FP/129/25/HH

Blakes Cottage 1 Blakes Road Felpham PO22 7EB

Replacement of first floor masonry and thatched roof, minor masonry works including erection of a new pitch, thatched, roof with hips to the east and internal alterations including relocating walls and removal of two east chimney stacks.

Title
SOUTH & EAST ELEVATIONS

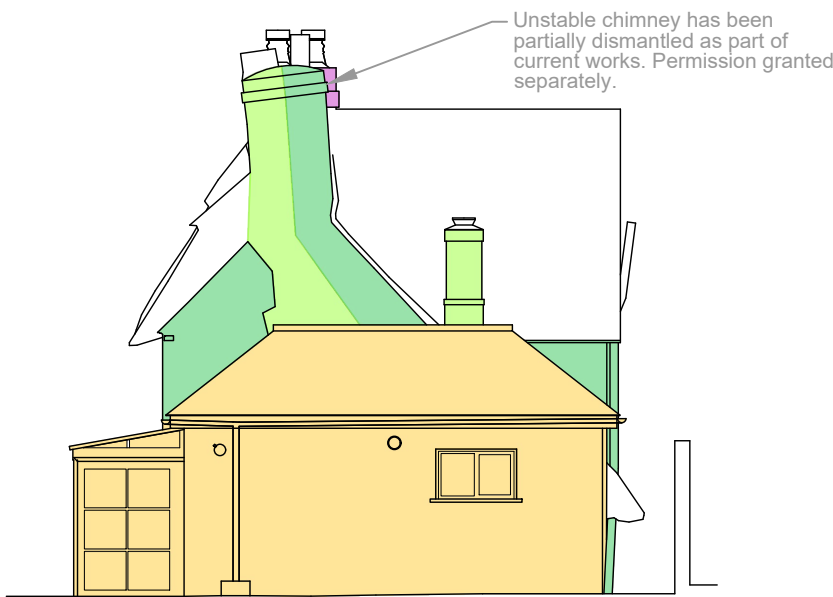
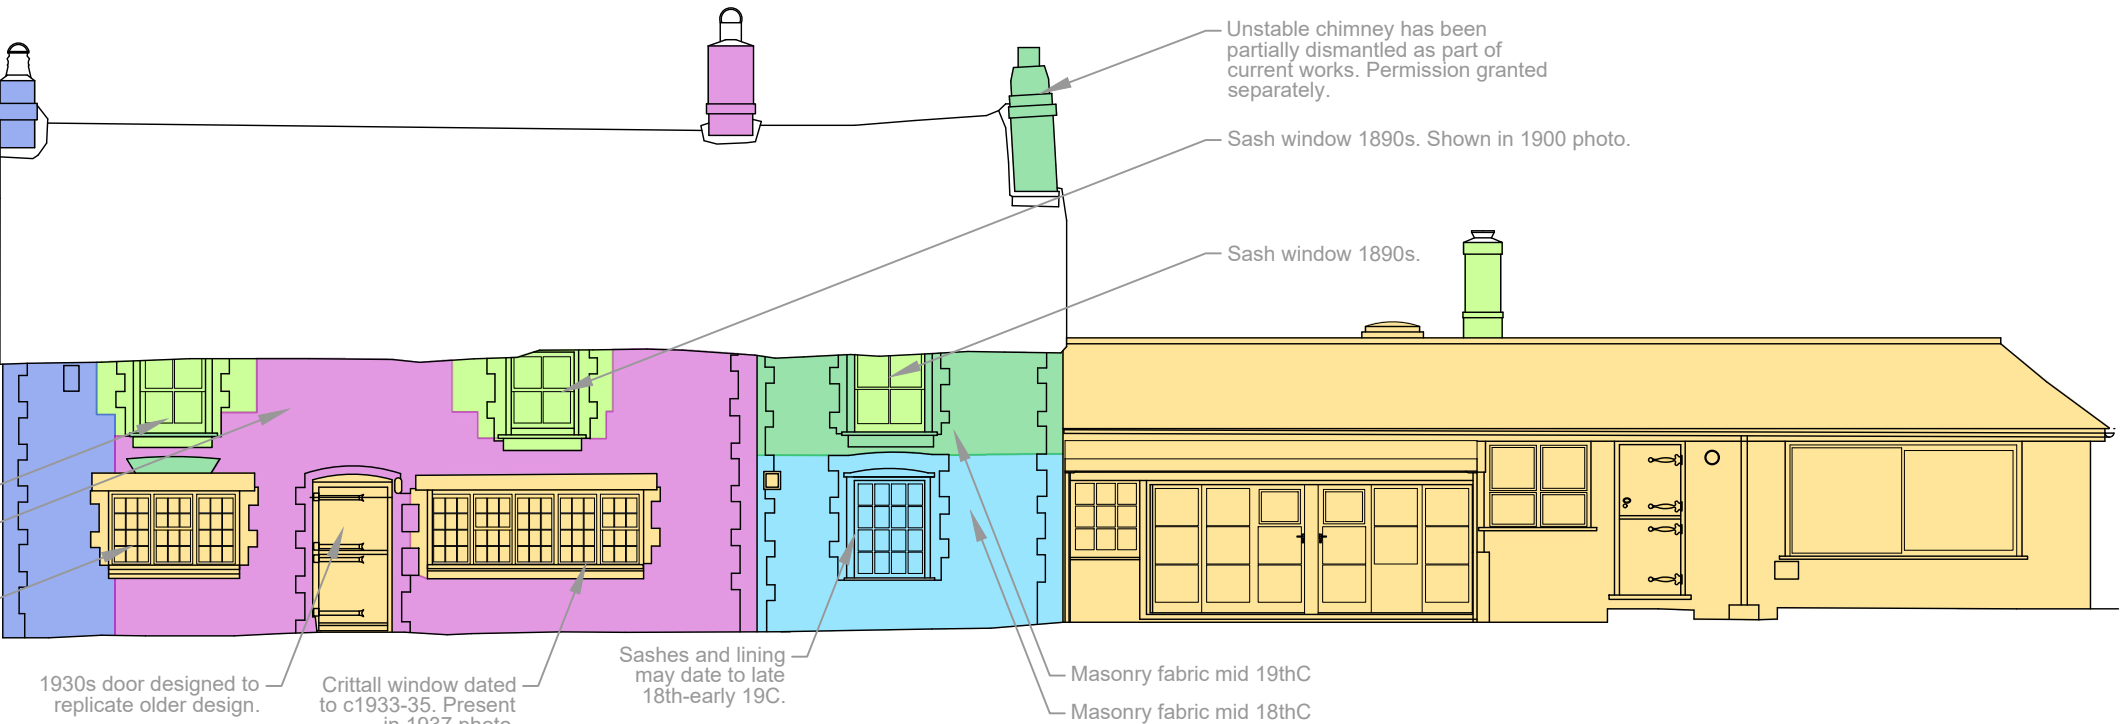
The proposed removal of the mid-19th-century first floor and associated pitched roof will result in the loss of historic fabric, including masonry, joinery, chimney stacks, and a small winding staircase. This intervention represents a degree of harm to the building's layered history and material authenticity.

Title
ROOF PLAN

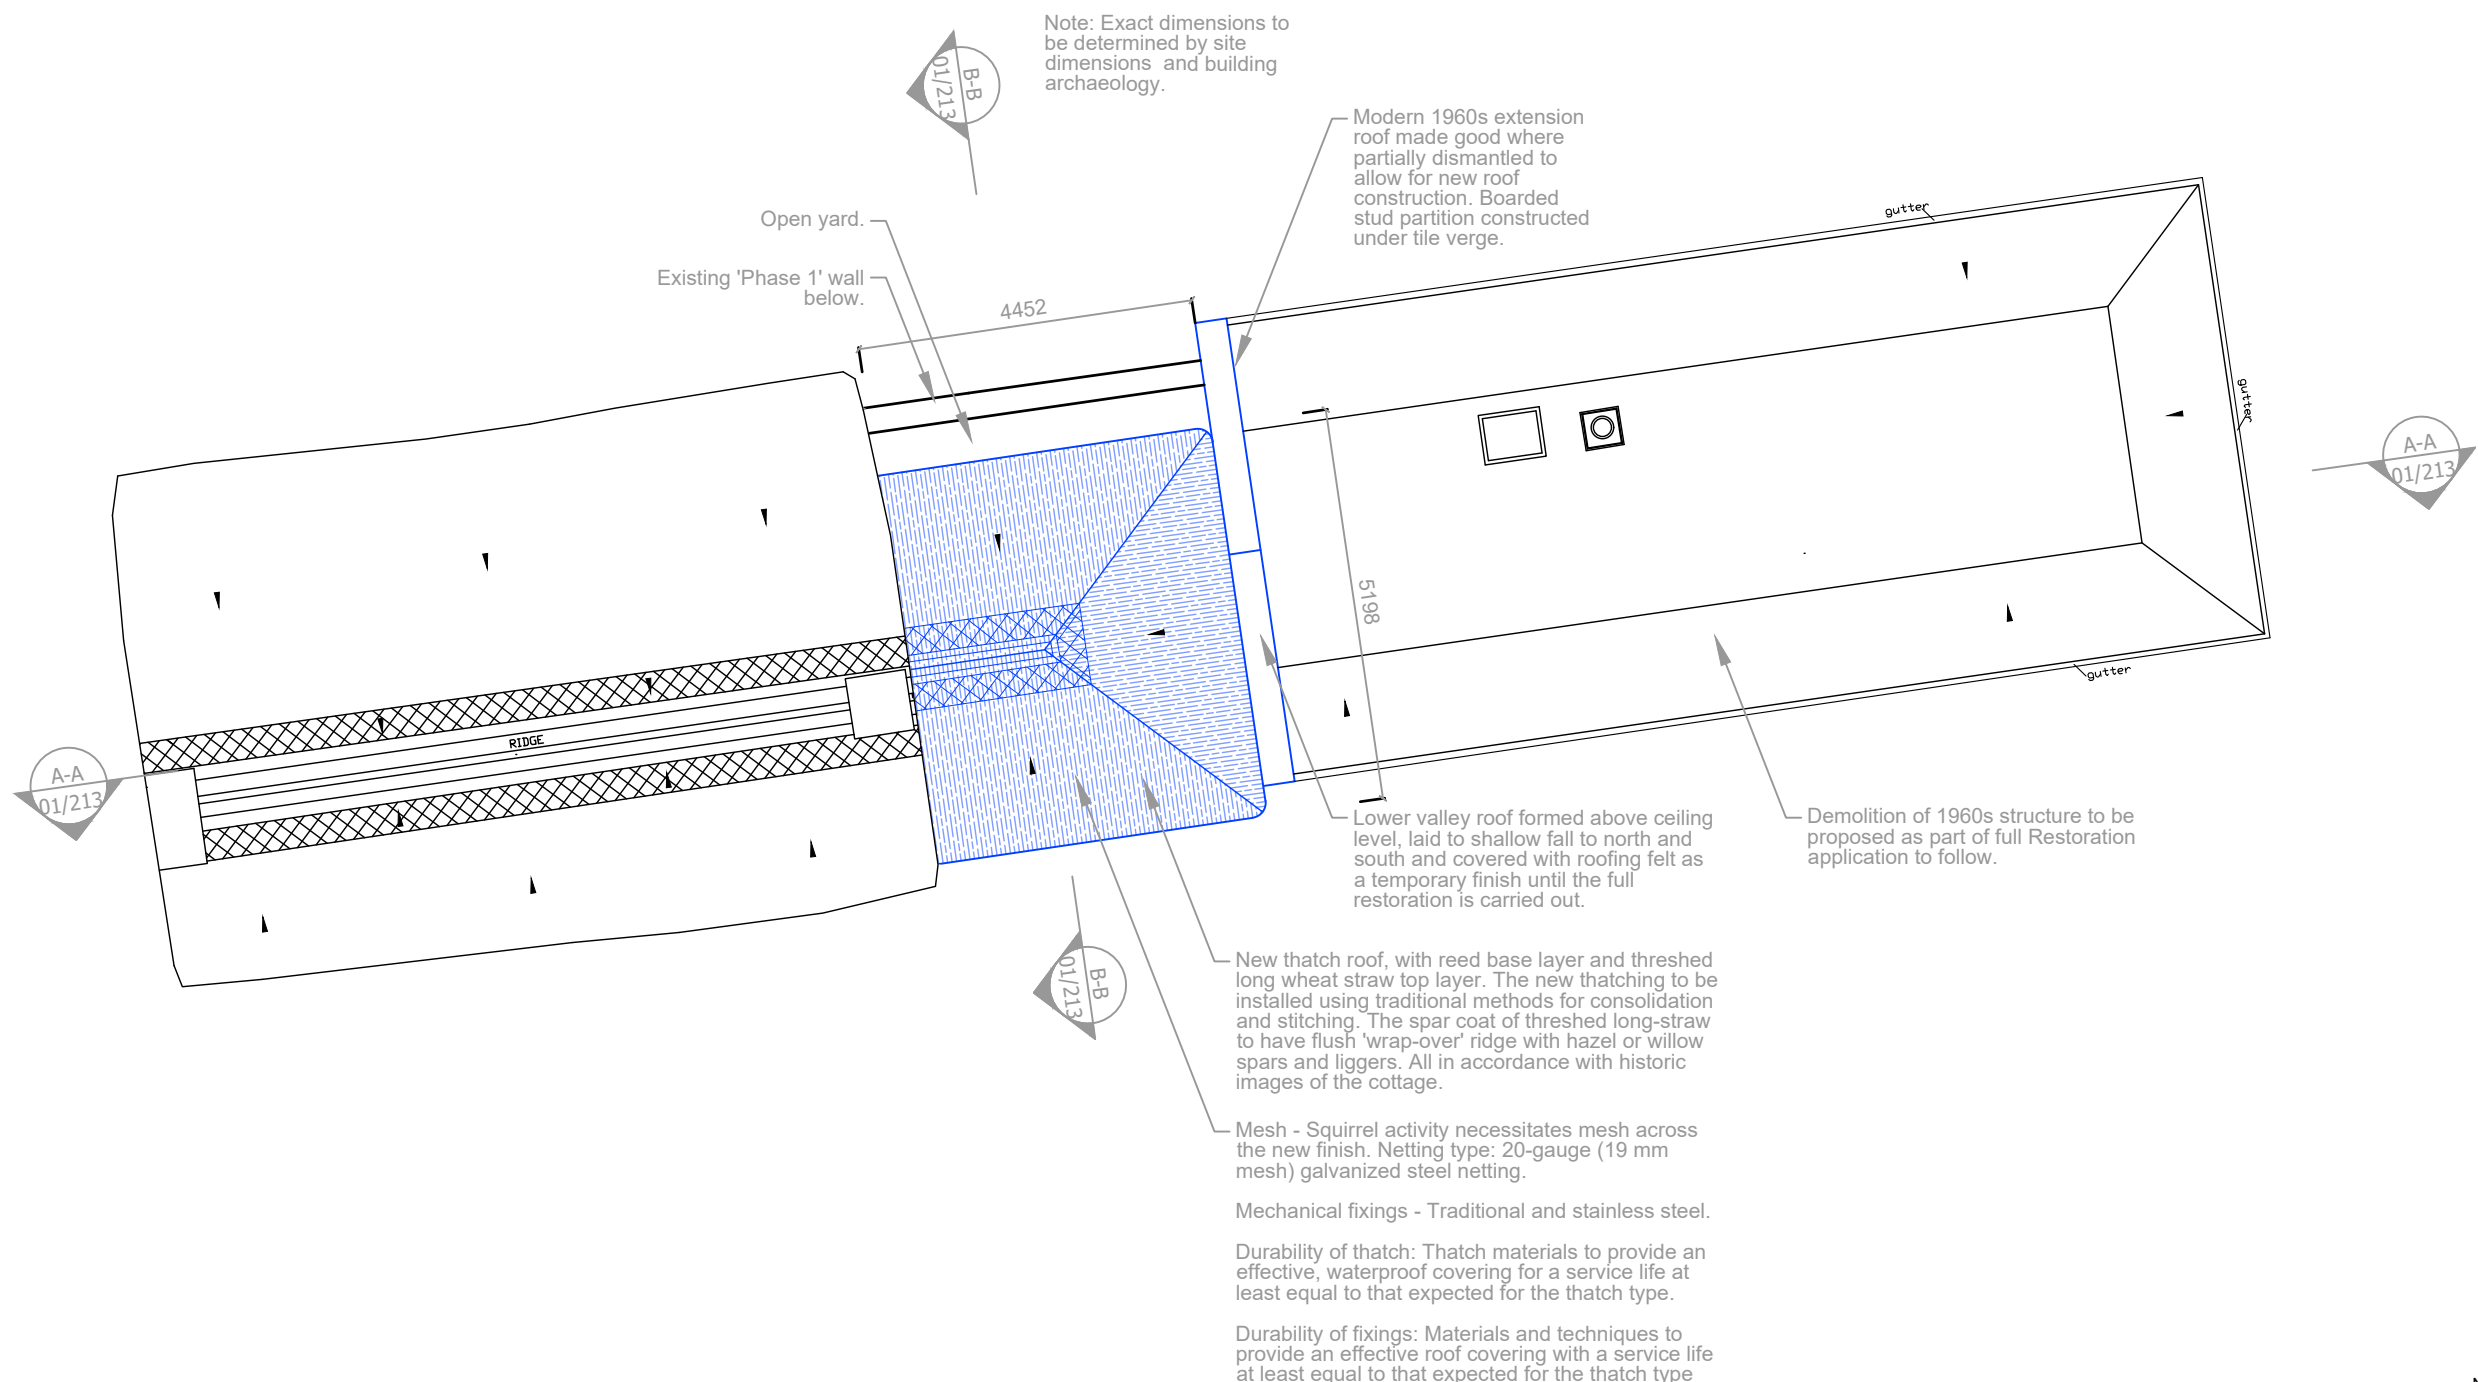
application is removing the first floor 19th century element (with pitched roof) and replacing it with a new thatched roof over the ground floor.
